From: Michael Eastham
Sent: 17 December 2018 14:08
To: 'Kenny, Darren'
Cc: Planning.Responses
Subject: FW: *EXTERNAL: FW: Kingley Gate outstanding Obligations and Conditions - LU/283/18/DOC

Please see the consultation response from the Local Highway Authority to the revised plans for LU/283/18/DOC.

LU355-10 (LU/282/17/RES changing rooms and mixed use building)

- 4485_257M External Works
- 4485_259G Drainage Layout.

Drawing Number
4485/257

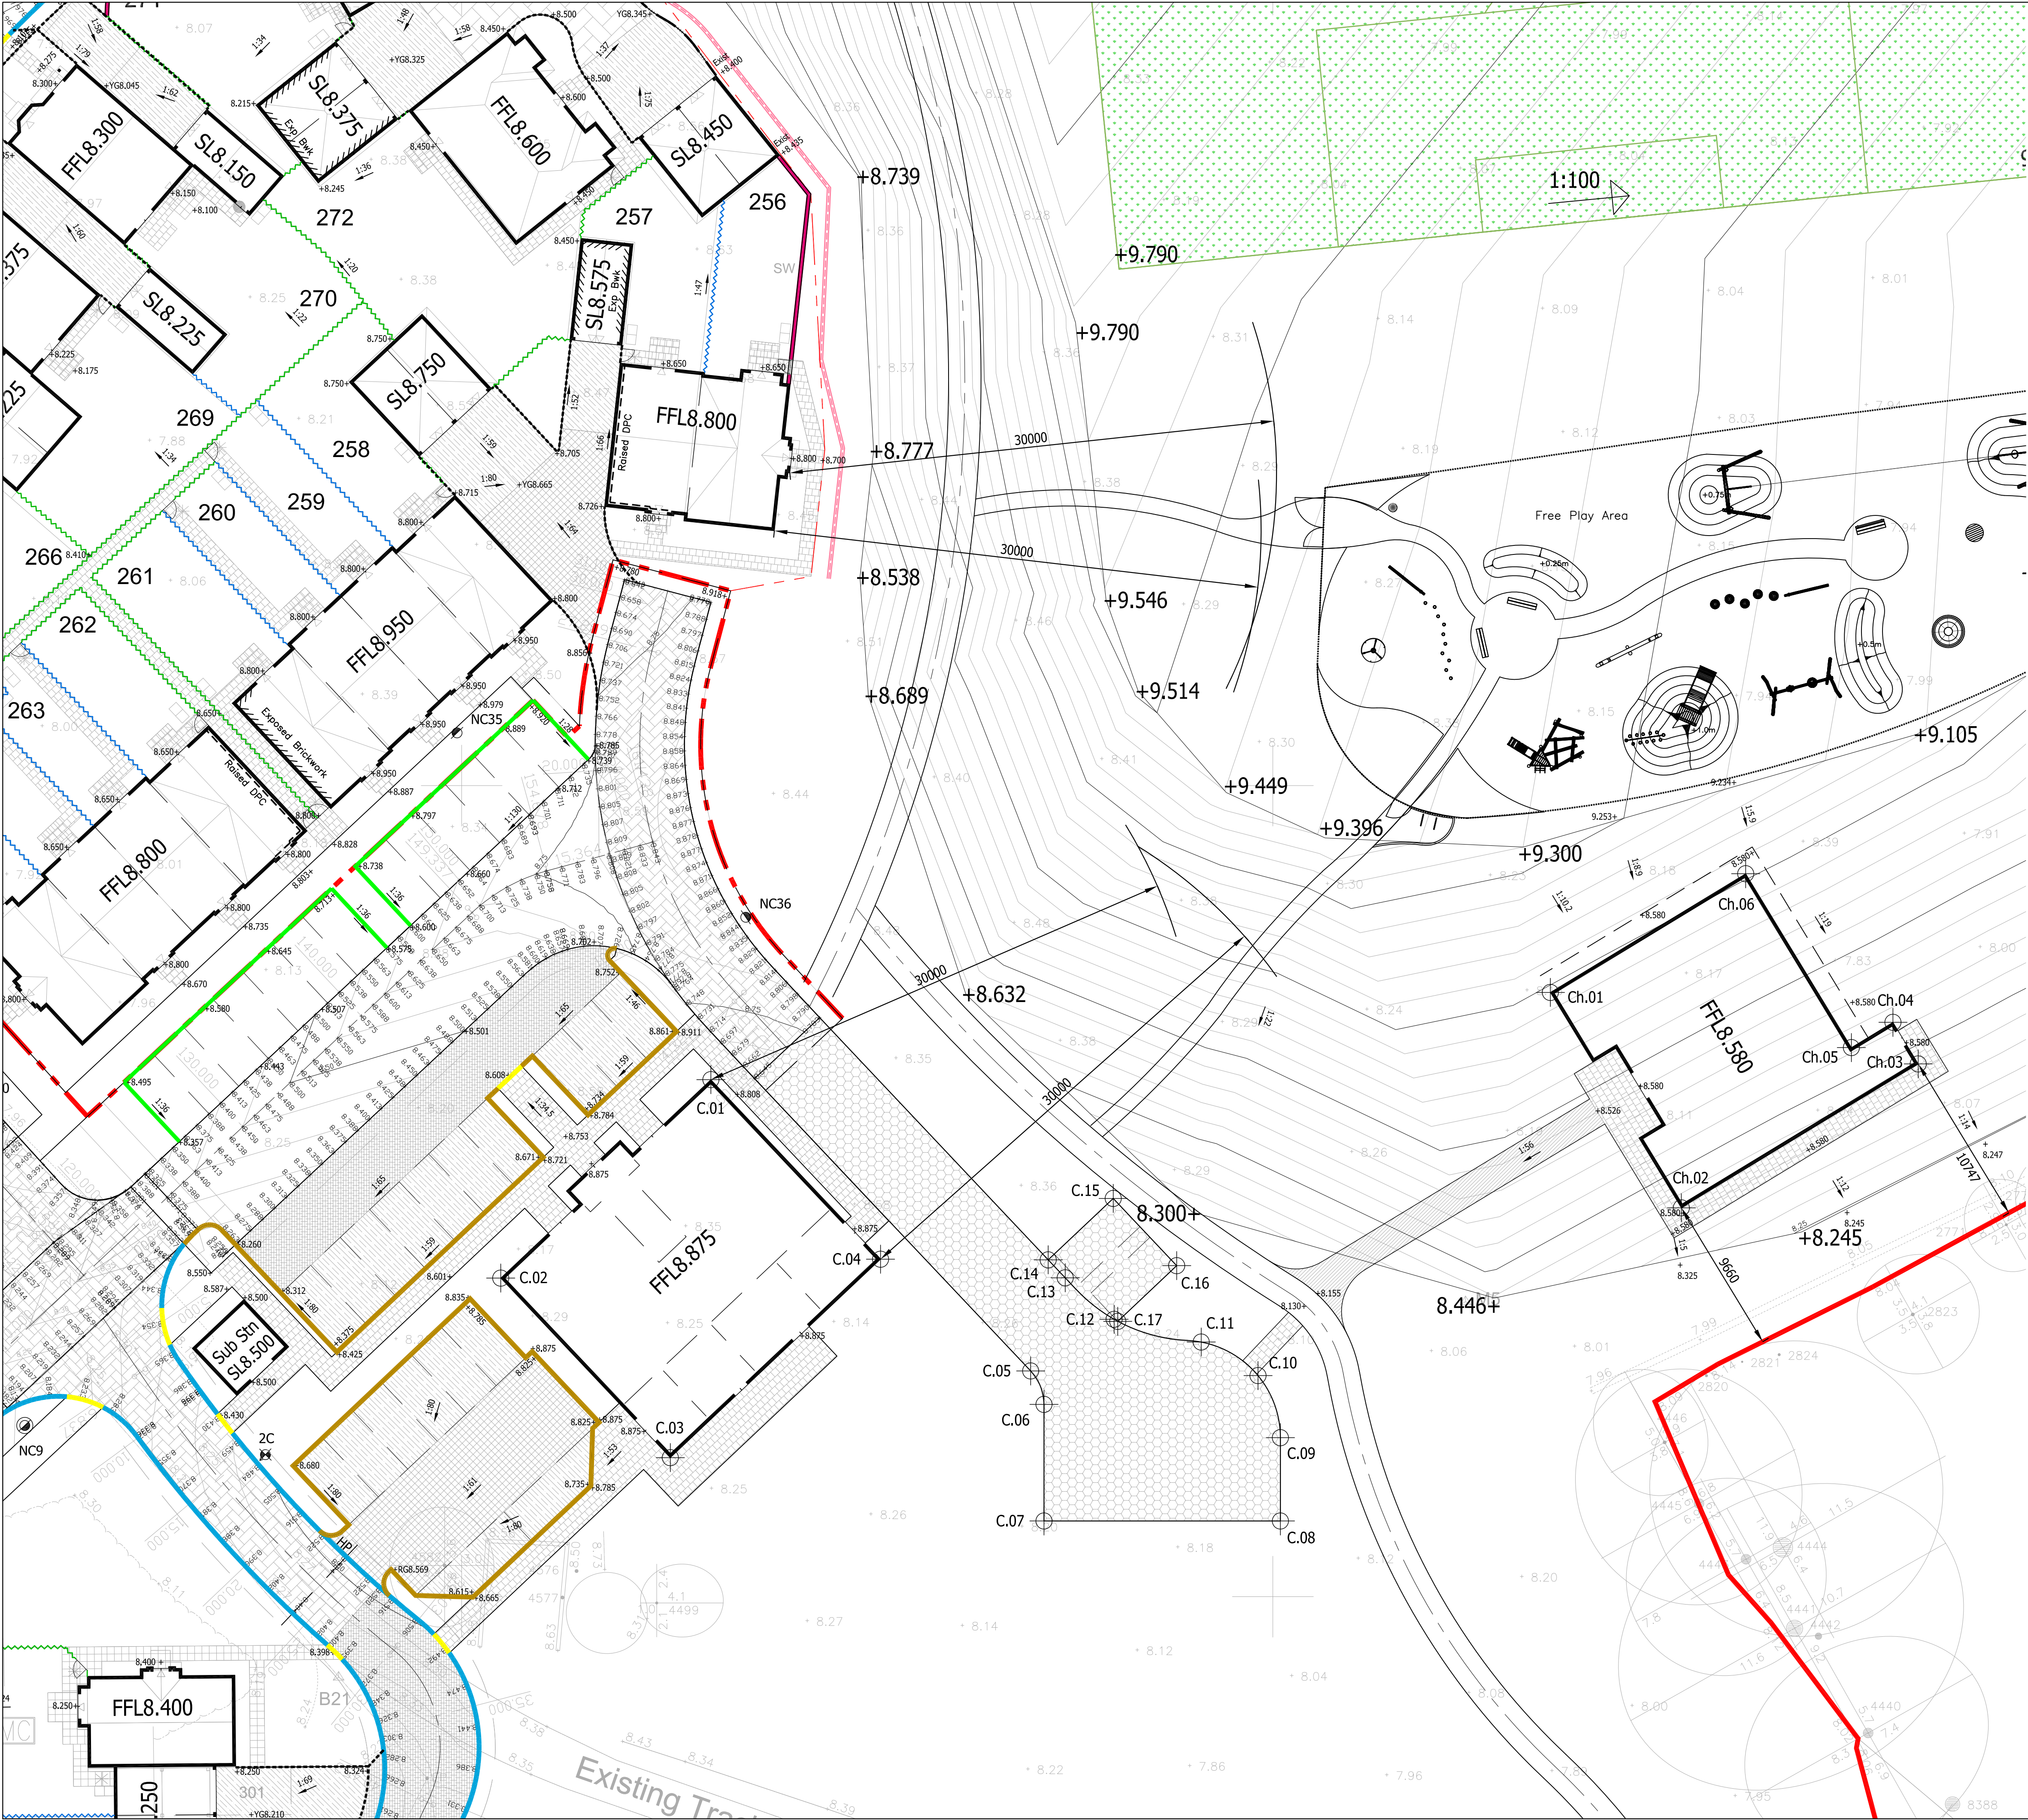
Looking at the parking assessment made previously at the outline stage by one of my colleagues, this suggested that based on current parking guidance, 46 spaces would be recommended based on the floor areas of the buildings in question. At that stage it was also suggested that a further informal area affording an additional 20 spaces might be available if required.

Looking at the latest plans found attached to your email, a total of 45 spaces now appear to be shown marked-out if one takes into account the spaces to the west of the commercial building (so just 1 space less than the guidance recommends). What is not known is whether any informal parking is still offered.
